Application reference: 16034/APP/2026/31, London Borough of Hillingdon (Local Authority)
Site: Rosedale College, Wood End Green Road, Hayes UB3 2SE

Responses to Sport England comments Community Use Agreement

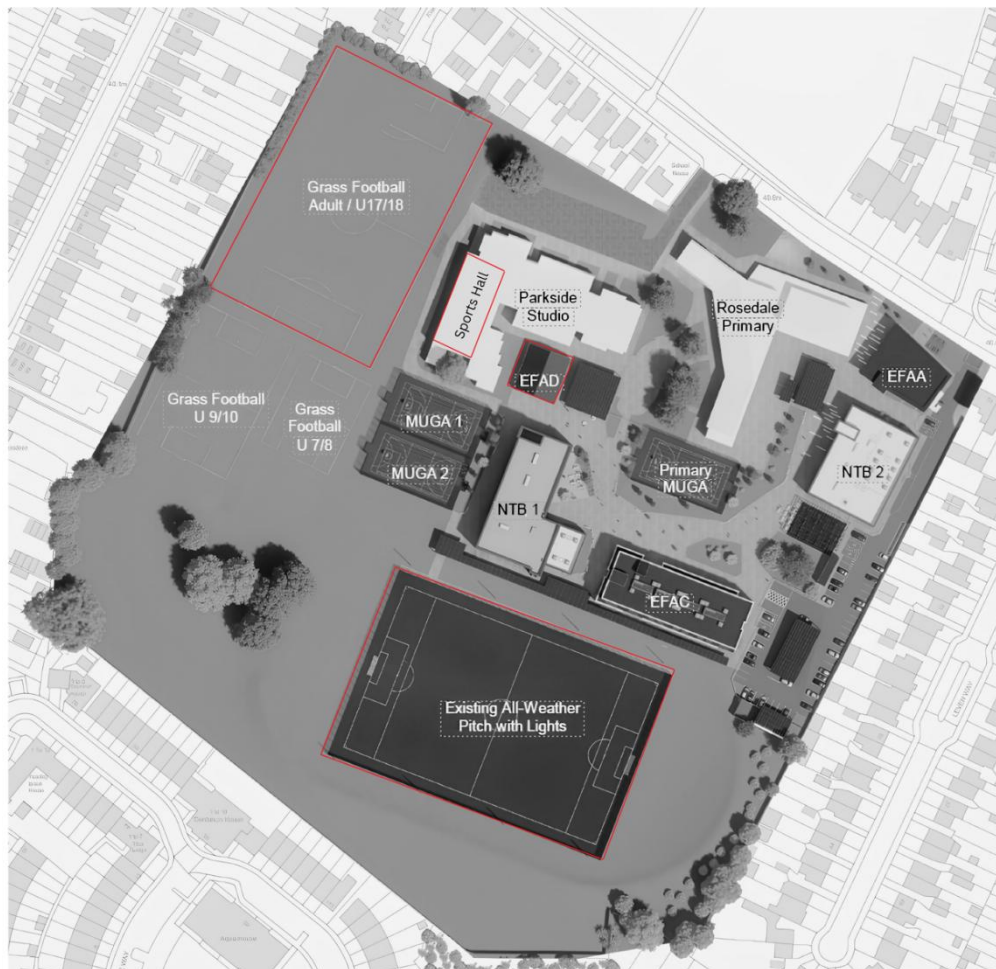
- Schedule 1 refers to '*Grass Pitch*' in the list of facilities available however there is more than one grass pitch on the drawing therefore please amend this to '*Grass Pitches*'

It is not pitches; it refers to the pitch outlined in red (please refer to the map)
